Recommendation Report for Planning Permission**REF NO:** WA/48/14/PL**LOCATION:** Deans Yard
Orchard Way
Fontwell**PROPOSAL:** Demolition of existing commercial buildings/garages and erection of 3 No 2 bed terraced dwellings along with provision of ancillary parking, turning and landscaping (re-submission of application WA/52/13).**SITE AND SURROUNDINGS**

Proposed Site Layout

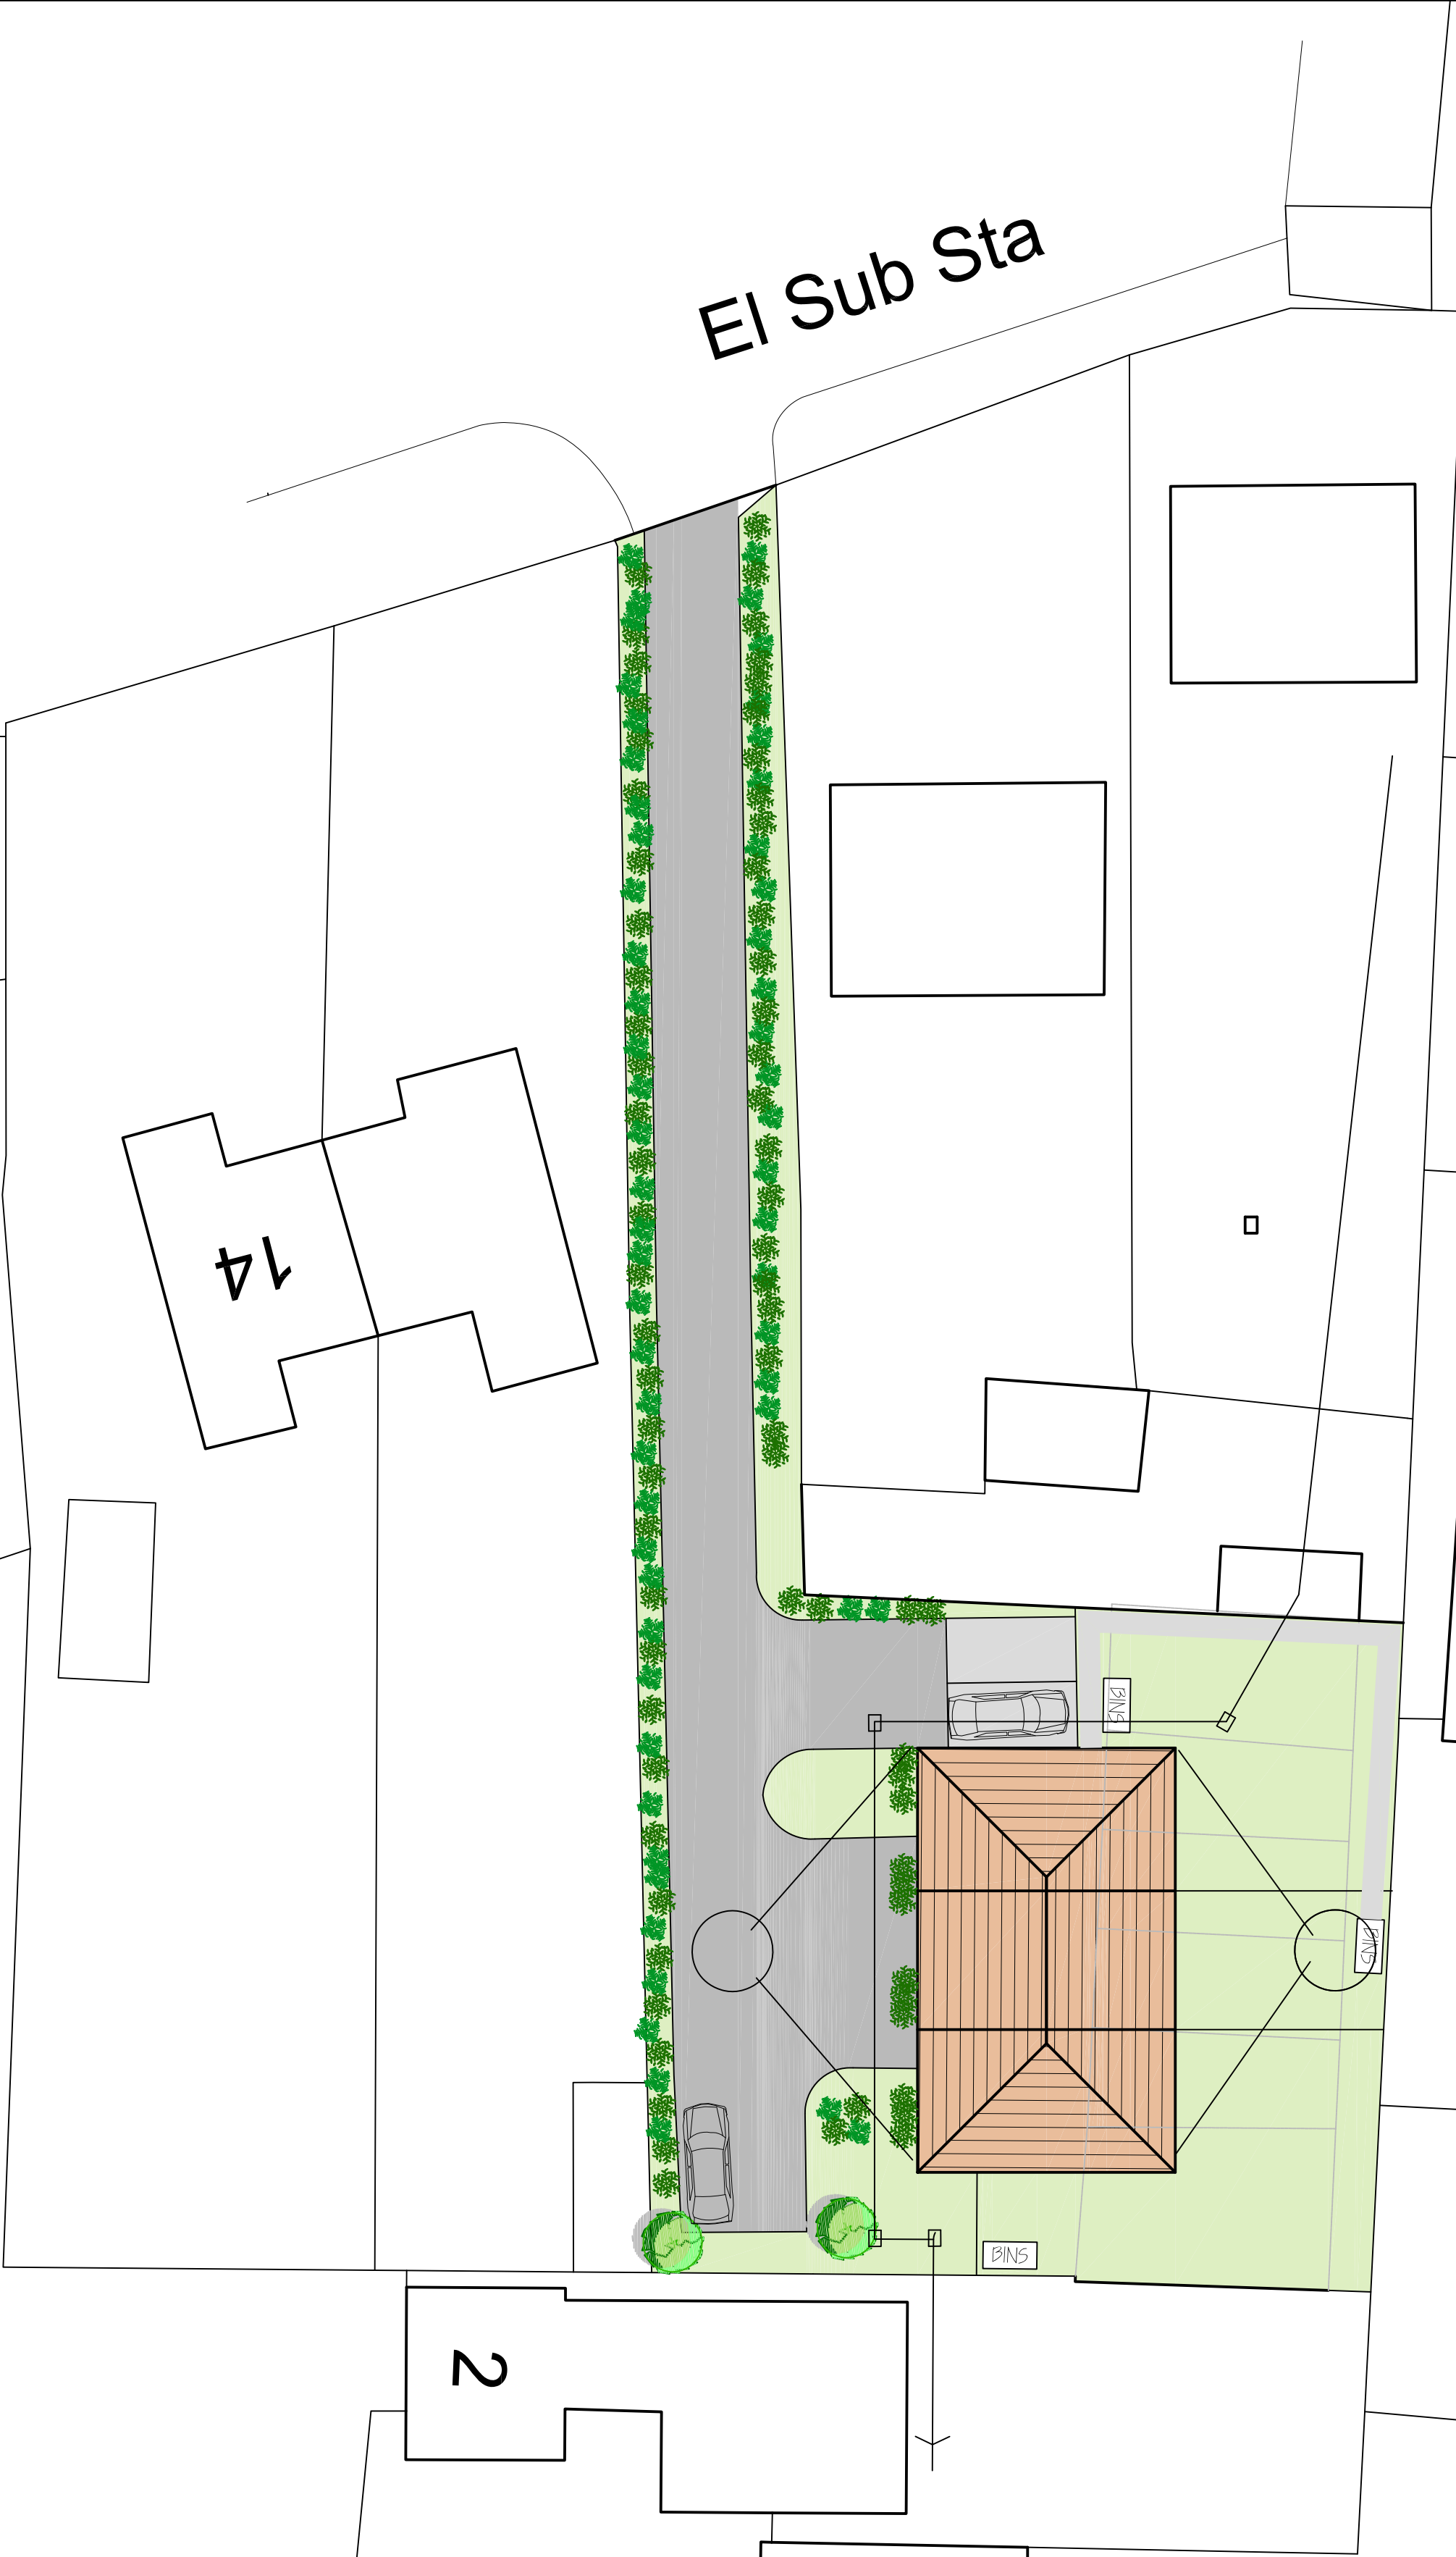
This application principally differs by now proposing 3no. 2 bed dwellings, a reduction of one bedroom. The terraced row of three properties have also been moved further away from the rear southern boundary by approximately 3.8m.

Stepping the southernmost property further away from the southern boundary by approximately 3.8m would not be sufficient to outweigh this harm and the scheme still has an overdeveloped cramped form and appearance. Therefore, the concerns with the previous application have not been successfully overcome and it still causes harm to the visual amenities of the area.

Whilst the rear gardens exceed the required 50 sq m in area, the depth of the gardens at approximately 7.8m does not meet the required distance of 10m. The scheme therefore conflicts with policy D DM3 of the Emerging Local Plan.

There is a gap of approximately 3.8m between the southernmost unit and no. 2 Deans Close which is a considerable improvement on the previous distance of 2.2m in application WA/52/13. Even so, the southern boundary which comprises of 2m high brick walling will not be sufficient to acceptably screen the new development at two storeys in height. The situation is not assisted by

This spatial relationship between the proposed dwellings and no. 2 still results in a conflict with the 45 degree rule. This Council has adopted the 45 degree rule for determining planning application to the rear of properties so as to ensure that any development does not seriously affect a neighbour's outlook or daylight. In this case the southernmost unit would intercept the 45 degree line when the line is drawn from the nearest window on the rear elevation of no. 2 Deans Close. It is therefore considered that the development would harmfully and unacceptably effect the outlook for this neighbouring property, as well as causing a harmfully oppressive and unneighbourly effect for approximately half of its garden. Whilst the existing commercial units extends almost to the end of the garden of no. 2, this is single storey in height and the portion of garden closest to this neighbouring property is undeveloped. In contrast, the proposed scheme would result in the southernmost dwelling at two storeys in height extending immediately to the rear of no. 2 which will have a harmfully oppressive and unneighbourly effect. Additionally, the benefits of replacing commercial with residential development and providing a gap of 3.8m to the southern boundary would not be sufficient to materially outweigh the harm caused by the scheme.

- 1 The proposed dwellings by virtue of their number and site coverage compared to the plot size would cause harmful over-development and would be unacceptably contrary to the prevailing development pattern of the surrounding area in conflict with policy GEN7(ii) of the Arun District Local Plan and policies D DM1 and D SP1 of the Emerging Local Plan and the National Planning Policy Framework.

- 3 The proposed southernmost dwelling by virtue of its size and layout within the plot would result in a harmful loss of outlook and create an oppressive and unneighbourly effect on no. 2 Deans Close which would be to the unacceptable detriment of current and future occupiers in conflict with policy GEN7(iv) of the Arun District Local Plan, policy D DM1 of the Emerging Local Plan and the National Planning Policy Framework.

PROPOSED GROUND FLOOR LAYOUT PLAN

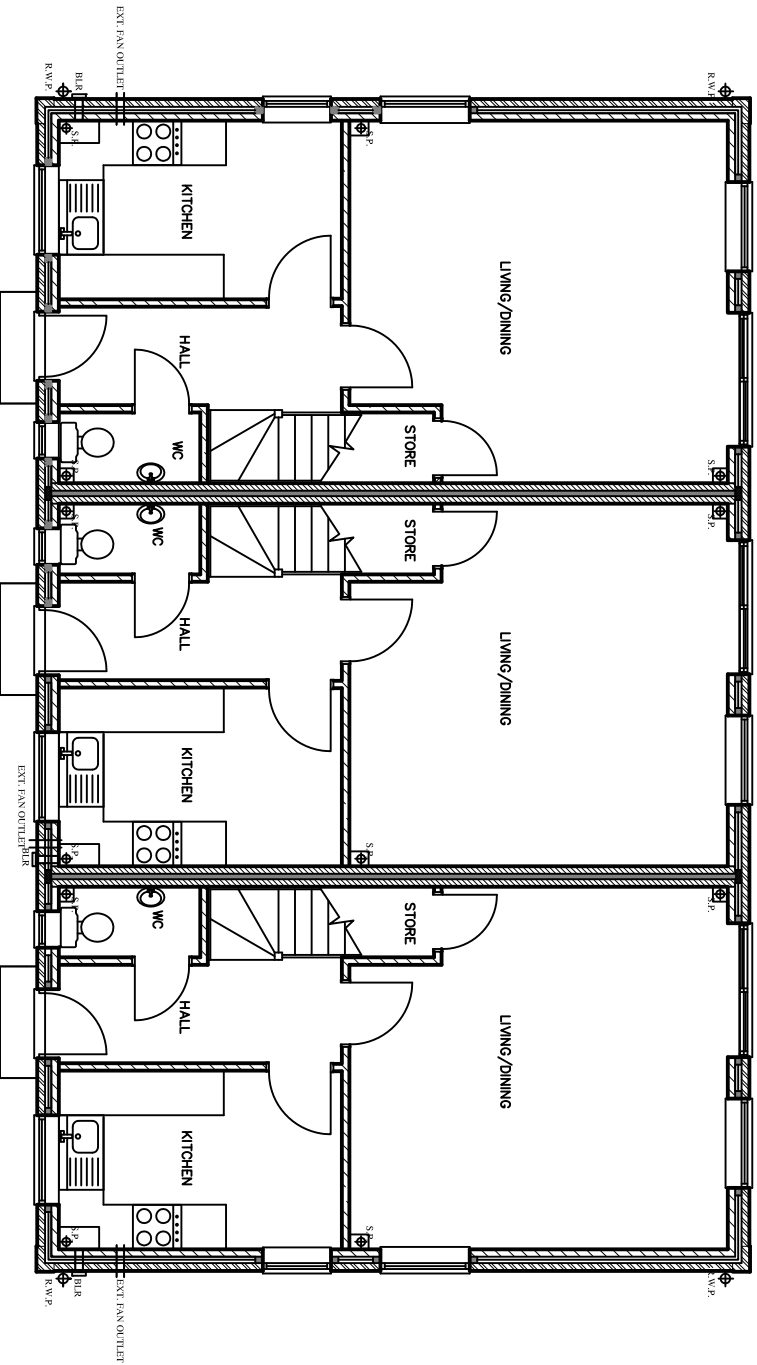
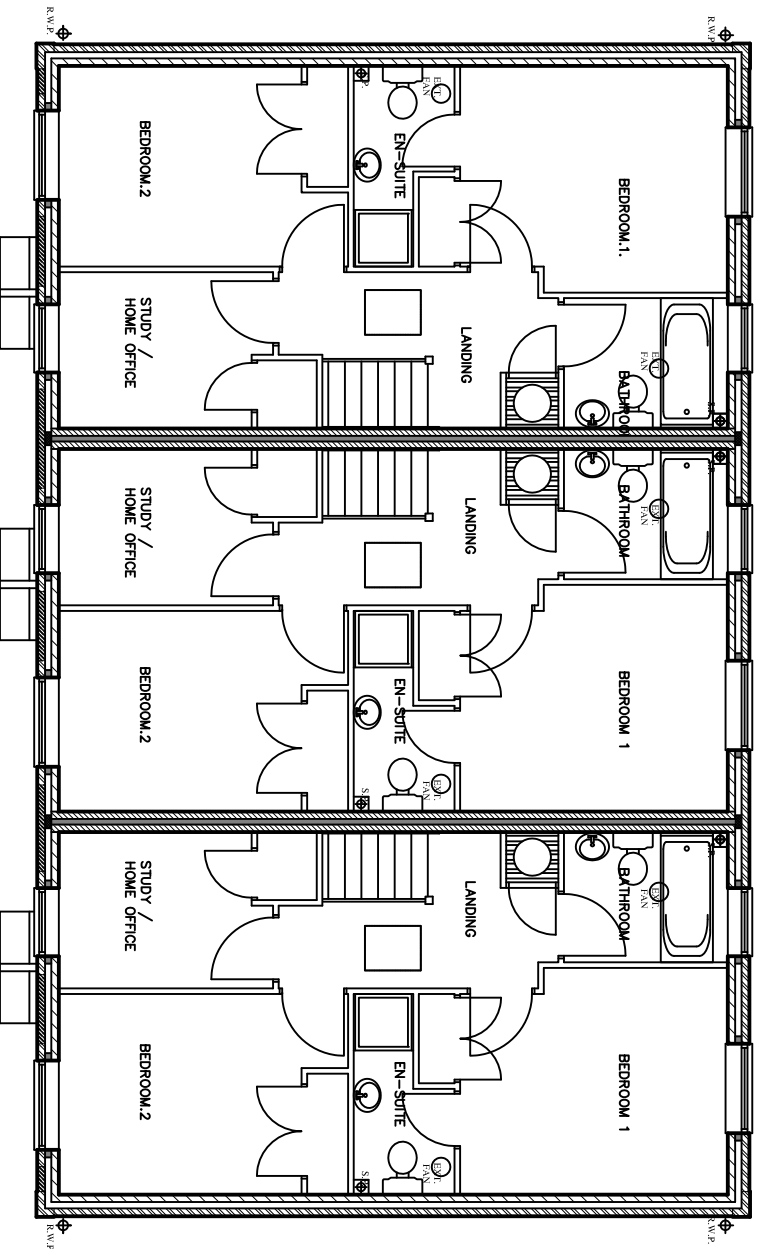
There are shortfalls in the minimum room sizes for the 3no. dwellings. The living/dining rooms for all 3no. dwellings measure approximately 24.5 sq m compared to the required 26.8 sq m. Bedroom 1 in all three dwellings measures approximately 10.5 sq m and should be 12 sq m (double room). The ensembles on the first floor for all dwellings measure approximately 3.78 sq m compared to the required 4.4 sq m. The WCs on the ground floor for all dwellings measure approximately 1.8 sq m and should be 2.7 sq m.

This failure to comply with the internal space standards is further indication for the cramped and over-developed layout and appearance of the site. Since the room sizes do not meet the required standards, the scheme conflicts with policy D DM2 of the Emerging Local Plan.

- 2 The size of the proposed dwellings would result in an under-provision in room sizes and a shortfall of rear garden land that is in conflict with the Internal Space Standards of policy D DM2 and the External Space Standards of policy D DM3 set out in the Emerging Local Plan.
